**Our ref:** WA/2023/130309/01-L01  
**Your ref:** 23/00415/DISC  
**Date:** 31 March 2023

**Discharge Of Conditions 15 (Contamination), 16 (Contamination Remediation), 22 (Construction Phasing Plan), 23 (Surface Water Management Strategy), 24 (Flood Exceedance Plan), 25 (Infiltration Testing), 26 (Drainage Layout), 27 (Water Quality), 32 (Permeable Paving) And 33 (Suds Maintenance And Management Plan) Of 22/01144/F**

**OS Parcel 5700 South West Of Grange Farm, Street Through Little Chesterton, Chesterton**

SOAKAGE TRIAL PIT INFILTRATION TEST RESULTS

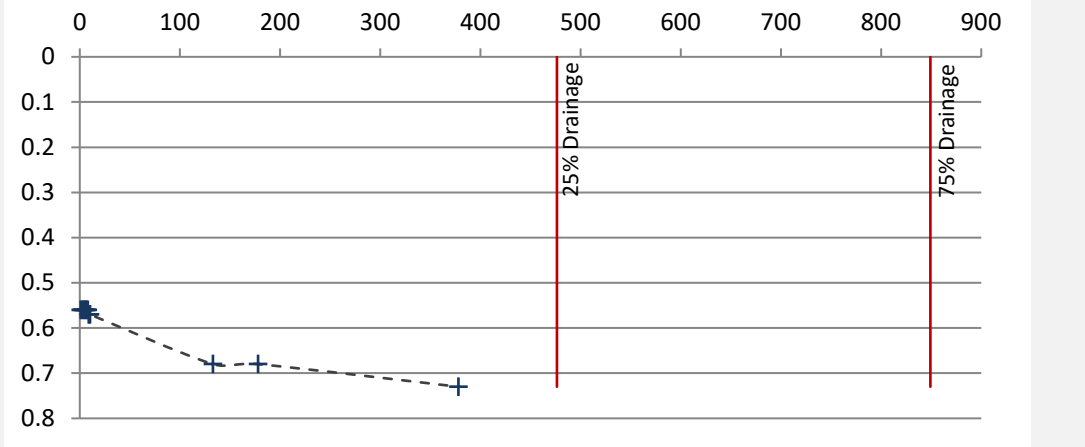
Shallow groundwater depths were measured across the site (in October 2021), and infiltration SuDS were also not deemed viable from the infiltration testing data: *None of the soakaway tests demonstrated sufficient reduction in water height to be considered viable.* Therefore, if the applicant seeks to discharge condition 6 (infiltration) in the future, we will not be able to be discharge the condition.
